February 27, 2009

Re: 661 Allen Avenue, Permit # 07-1319

CBL: 398-B-016001

PROPOSED STOVE PIPE INSTALLATION

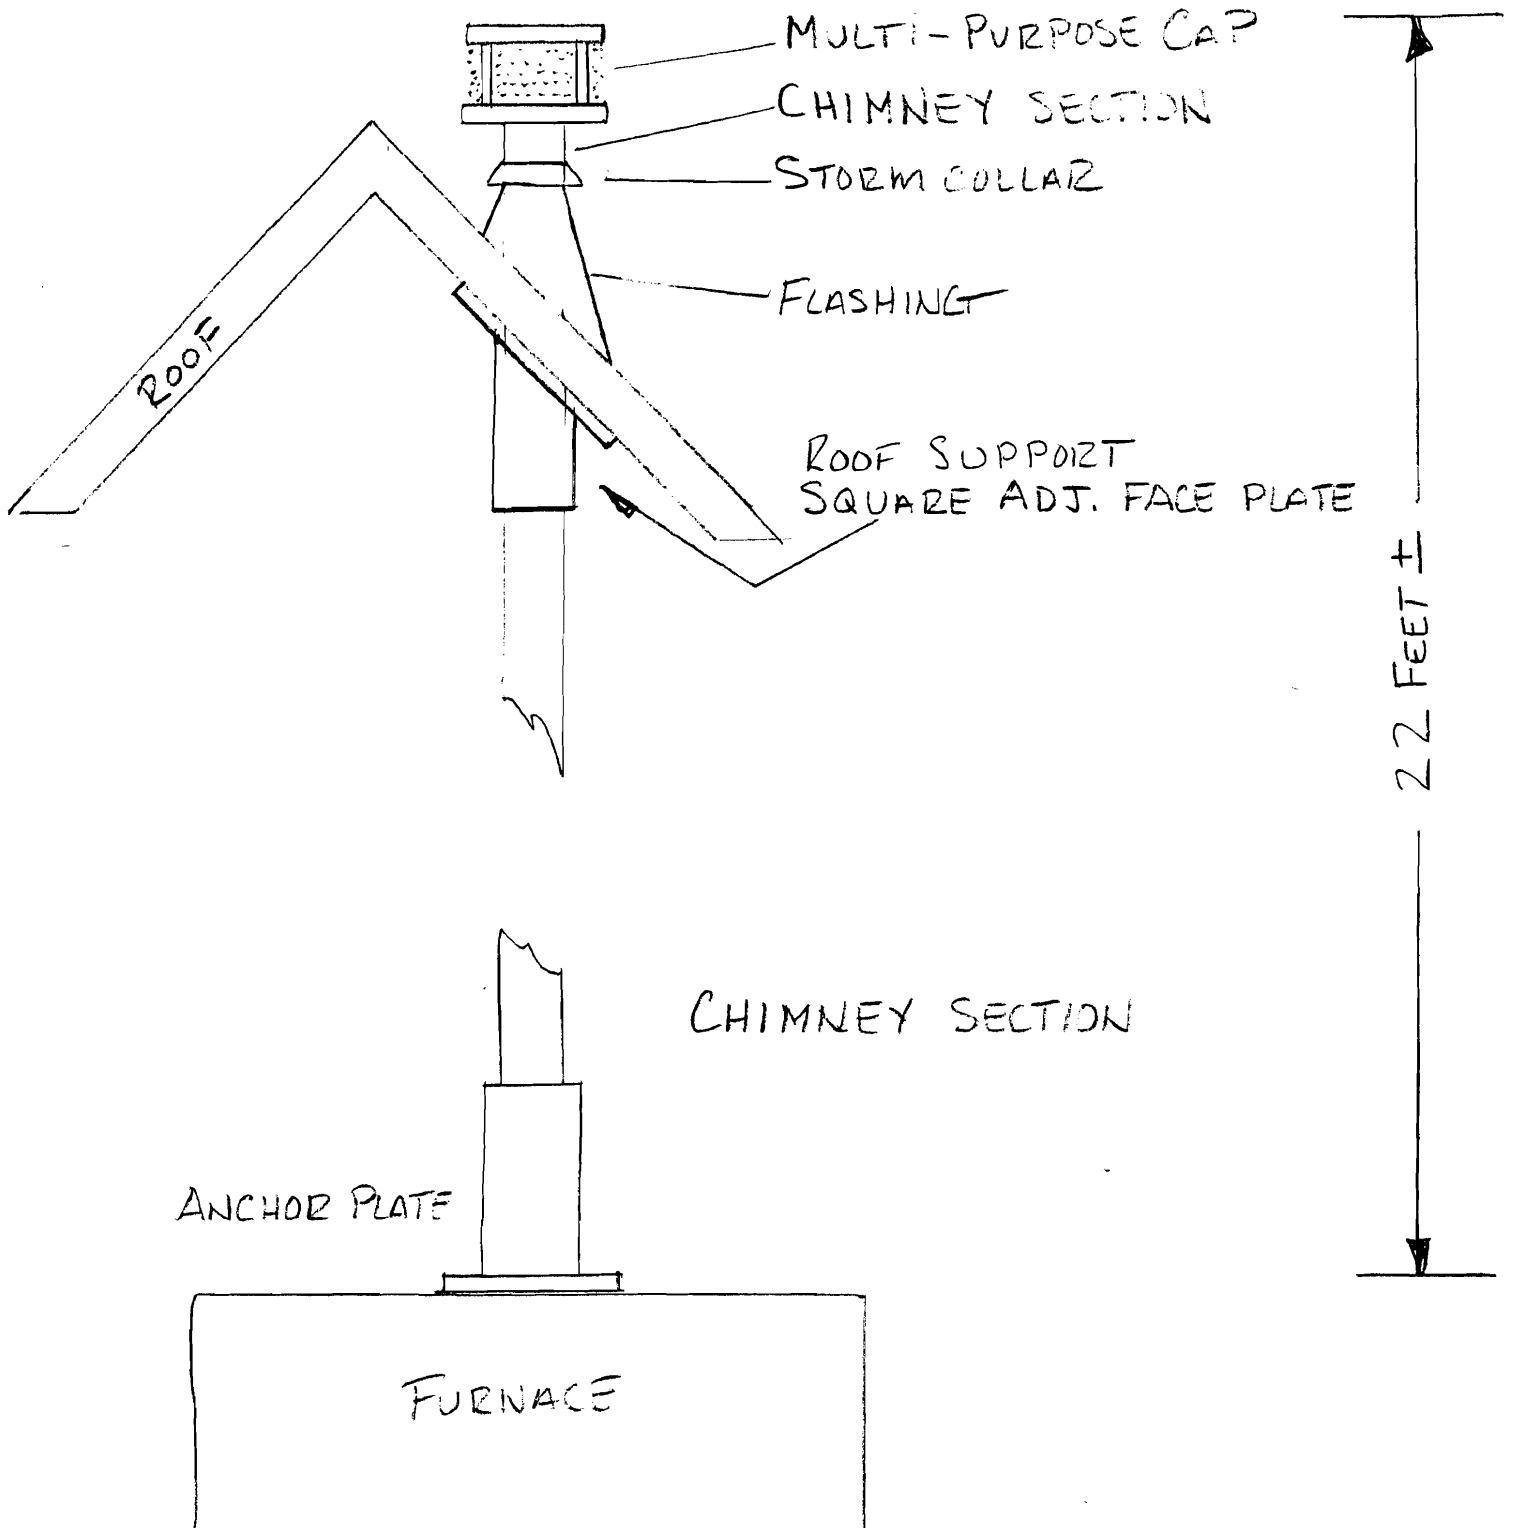
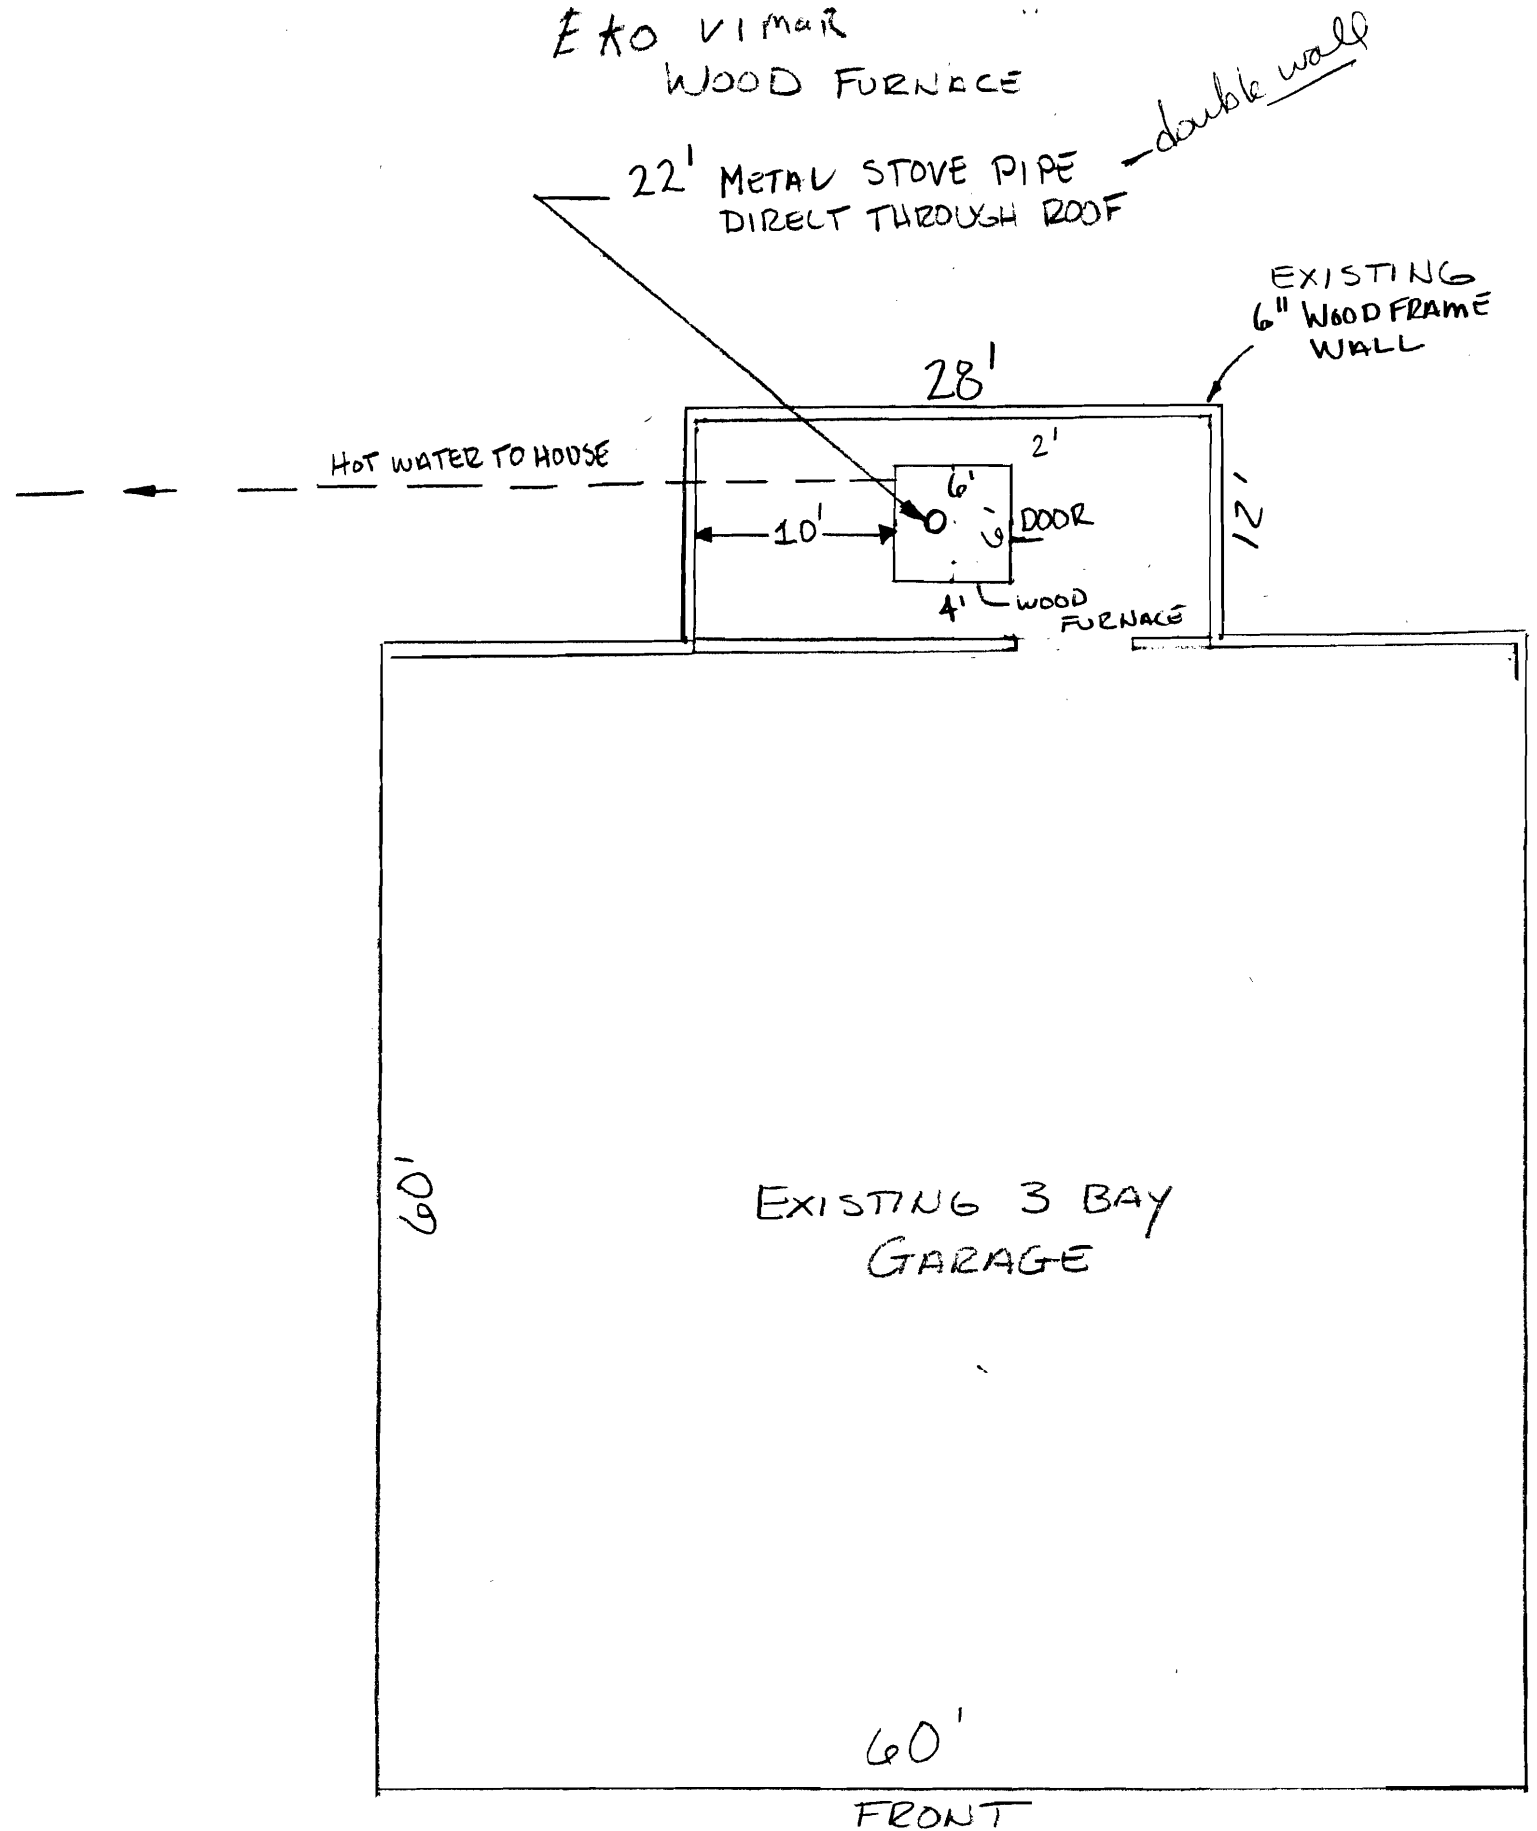
1. Accurate verification of required clearance to combustibles or compliant reduction method
2. Certification that the appliance meets DEP emissions control standards, setbacks to property lines and smoke stack heights.
3. The extension pipe/stack specifications
